**Moorebank Intermodal Precinct West - Stage 3 (SSD-10431)
Request for Additional Information**

I refer to the Department's assessment for the Moorebank Intermodal Precinct West - Stage 3 (SSD-10431). After careful consideration, the Department is requesting that you provide additional information.

The Department has reviewed the Moorebank Precinct West – Stage 3 Response to Submissions (RtS) (SSD 10431), dated 21 August 2020 (Aspect Environmental Pty Limited) and requests that you provide the following additional information.

Figure 1 - Proposed Subdivision Plan MPW Stage 3

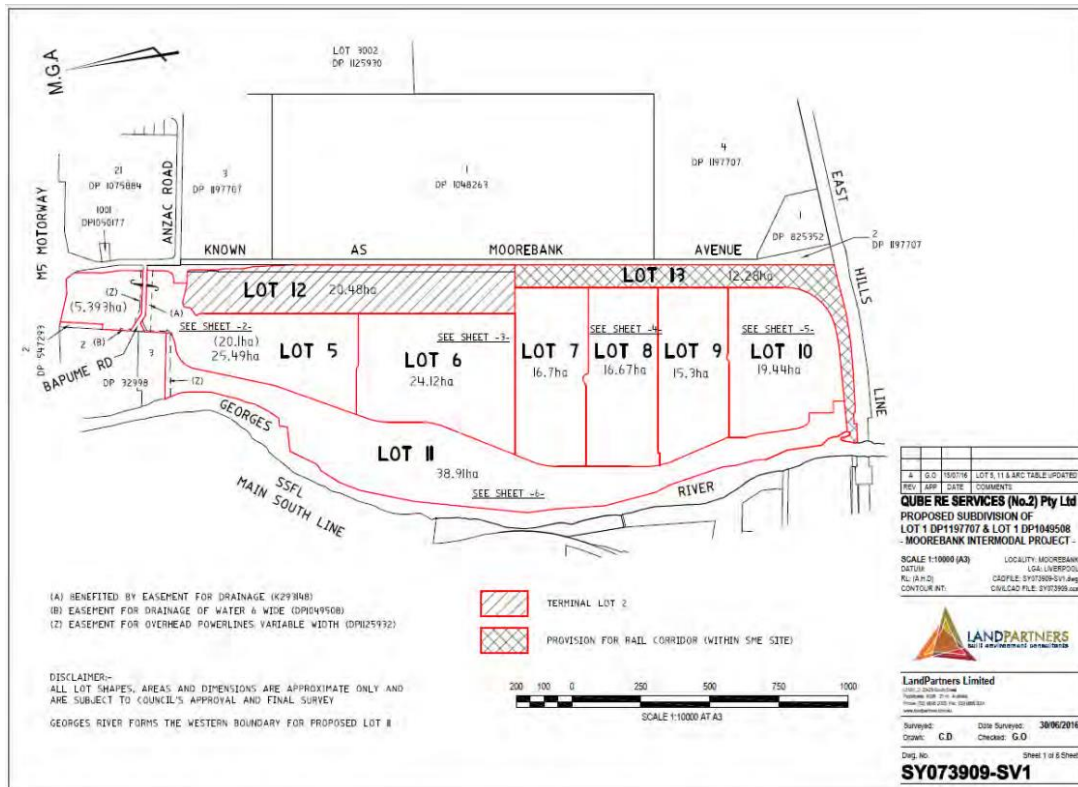
Please clarify as to whether the proposed subdivision configuration of lots 6 and 7 on the MPW Stage 3 subdivision plan are proposed to be amended to reflect proposed changes to the existing MPW Stage 2 warehouse configuration and operational boundary, as outlined in proposed SSD 5066 MOD 2 and SSD 7709 MOD 1 (see **Attachment 1**).
